## PEDESTRIAN FACILITIES, LAND AT SOUTH SIDE, STEEPLE ASTON, OXFORDSHIRE

### RESPONSE TO STAGE 1 ROAD SAFETY AUDIT

The following is provided in response to Stage 1 Road Safety Audit (Ref. TR8171225/GT/018) dated 5 November 2019, which was undertaken by Glanville Consultants in respect of the proposed delivery of pedestrian facilities at South Side, Steeple Aston, Oxfordshire. The works are proposed to accompany a modest residential development on land to the south of South Side.

Plan showing proposed pedestrian infrastructure along South Side

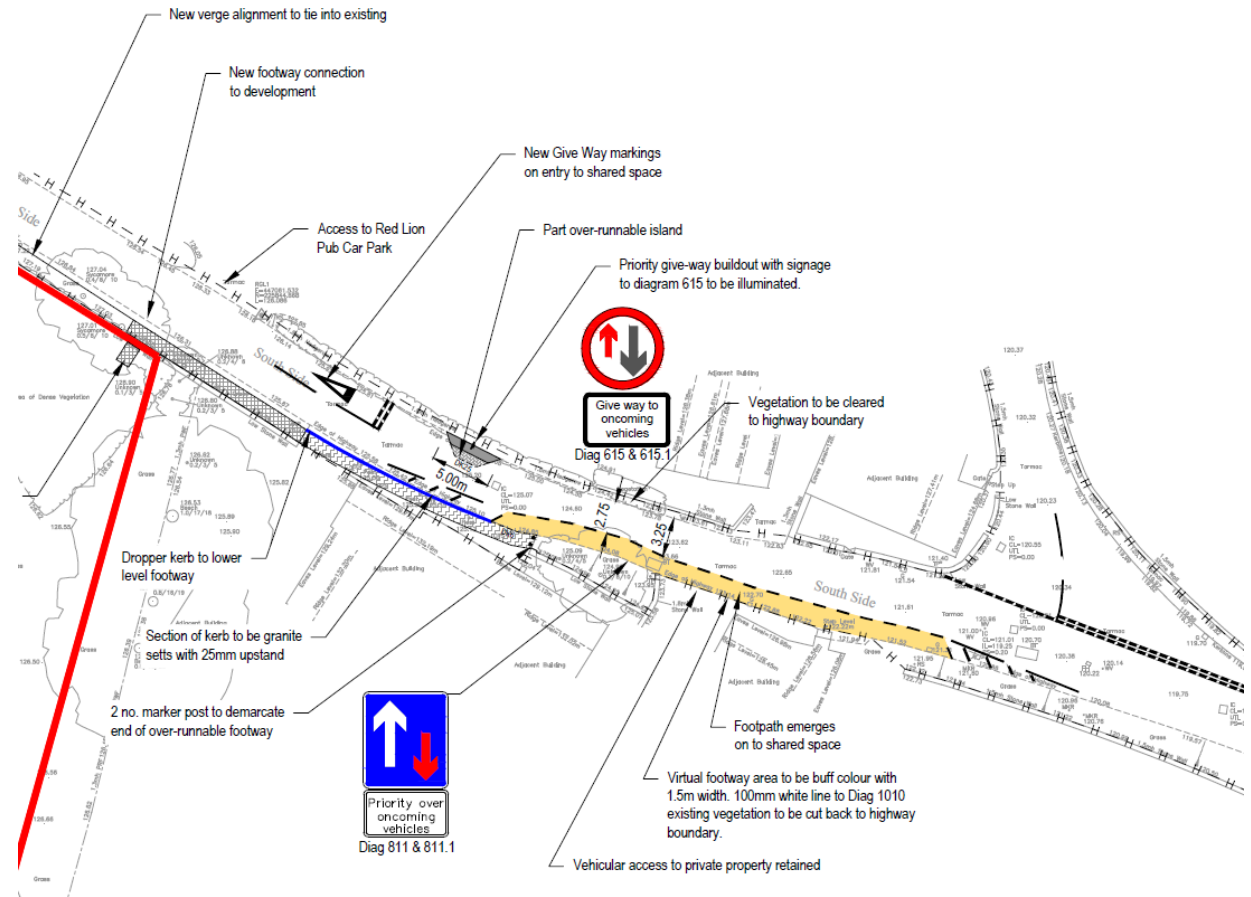
The existing nearside hedgerow on the eastbound approach to the proposed priority give way line was noted to partially obstruct forward visibility. This may result in drivers passing the give way line whilst having insufficient sight of on-coming vehicles travelling east to west along South Side. As a result, vehicles travelling west to east may be unable to sufficiently clear the proposed kerbed build-out, giving rise to a risk of either vehicle / vehicle head-on collisions or collisions with the build-out, both with possible personal injury occurring.

There is a concern that the proposed assembly comprising signs conforming to diag 615 and 615.1 will obstruct forward visibility for drivers of larger vehicles or SUVs travelling west to east who are likely to be seated in a more elevated position. This may result in drivers passing the give way line whilst having insufficient sight of on-coming vehicles travelling east to west along South Side giving rise to a risk of vehicle / vehicle head-on collisions with possible personal injury occurring.

The introduction of the virtual footway will locally reduce the carriageway width to 2.82 metres. Whilst the Audit Team accepts that the virtual footway is designed to be over-runnable, there is the potential that some drivers travelling west to east may be reluctant to use this additional width when attempting to overtake a cyclist or will be unable to use it if it is occupied by a pedestrian. There is a similar concern in respect of cyclists travelling in the opposite direction. This gives rise to a risk of collisions with possible personal injury occurring. [Note: Local Transport Note 1/07 (Traffic Calming) recommends that *'Total widths through narrowings of between 2.75 and 3.25 metres should be avoided if no cycle bypass is provided'*.].

A mix of over-runnable and kerbed footway will be provided between the development site and the virtual footway. There is a concern that larger vehicles passing similarly sized vehicles waiting at the priority give way will have to use part of the kerbed footway during this manoeuvre. This may lead to loss of control incidents and / or a risk of injury being caused to vehicle occupants.

Existing vegetation currently overhangs the route of the proposed virtual footway. This will cause obstruction leading to pedestrians having to step into the carriageway giving rise to a risk of vehicle / pedestrian collisions with possible personal injury occurring.

Pedestrians with a visual impairment are given no indication of where the over-runnable footway ends, and the virtual footway commences. Furthermore, all pedestrians must transfer to and from both footways via a dropped kerb with a 25mm upstand. There is a concern that an absence of demarcation at the end of the over-runnable footway and the kerb upstand may both give rise to trips or falls with possible personal injury occurring.

In order to demarcate the edge of the virtual footway it is proposed that directional red and white studs are installed. Conventionally white studs are used to indicate a traffic lane or centre of carriageway marking. Hence, their use in this instance may be confusing to approaching drivers giving rise to a risk of pedestrian / vehicle collisions with possible personal injury occurring.

The virtual footway terminates at its eastern end such that pedestrians are left exposed with no defined onward route using other existing facilities. The opposite, east to west route is also an issue since there is no defined route guiding pedestrians from existing facilities to the virtual footway. This may lead to confusion and a risk of pedestrian / vehicle collisions with consequent personal injury occurring.

As such, it is proposed that the nearside hedgerow on the eastbound approach is trimmed back along its length at least as far as the highway boundary.

For the above reason of there already being adequate forward visibility, it is not considered absolutely necessary to amend the island so as to become half over-runnable. However, the Design Organisation can see that there would be advantages of making the island half-over-runnable, in so much as it would allow vehicles to take 'avoidance action' if necessary, while providing additional room for larger vehicles to manoeuvre. As such, a half over-runnable solution is duly proposed, with commensurate relocation of the associated signage.

Notwithstanding, as noted above, it is proposed that the island is amended so as to become half over-runnable. This will mean the signs can be moved towards the nearside on the eastbound approach and out of the visibility splay of vehicles approaching the give-way from the west.

The Design Organisation accepts the Audit Team's recommendation. It is proposed that the carriageway width is reduced to be 2.75 metres at the pinch point, thereby discouraging drivers from attempting to pass a cyclist. This will also mean the virtual footway is slightly wider for pedestrians. To the east of this pinch point the carriageway opens out to be 3.25 metres wide or wider.

The Design Organisation accepts the Audit Team's recommendation. It is proposed the overhanging vegetation is extensively trimmed back to ensure that the full width of the virtual footway can be used by pedestrians.

The Design Organisation accepts the Audit Team's recommendation. A short length of dropped kerb with an upstand not exceeding 6mm is provided at the eastern end of the over-runnable footway.

Two bollards have been added to the design to demarcate the eastern end of the over-runnable footway.

Notwithstanding the demarcation having been previously agreed by the Highway Authority, the Design Organisation accepts the Audit Team's concerns. It is proposed that the virtual footway is demarcated with a white line to diag 1010 and that studs are omitted.
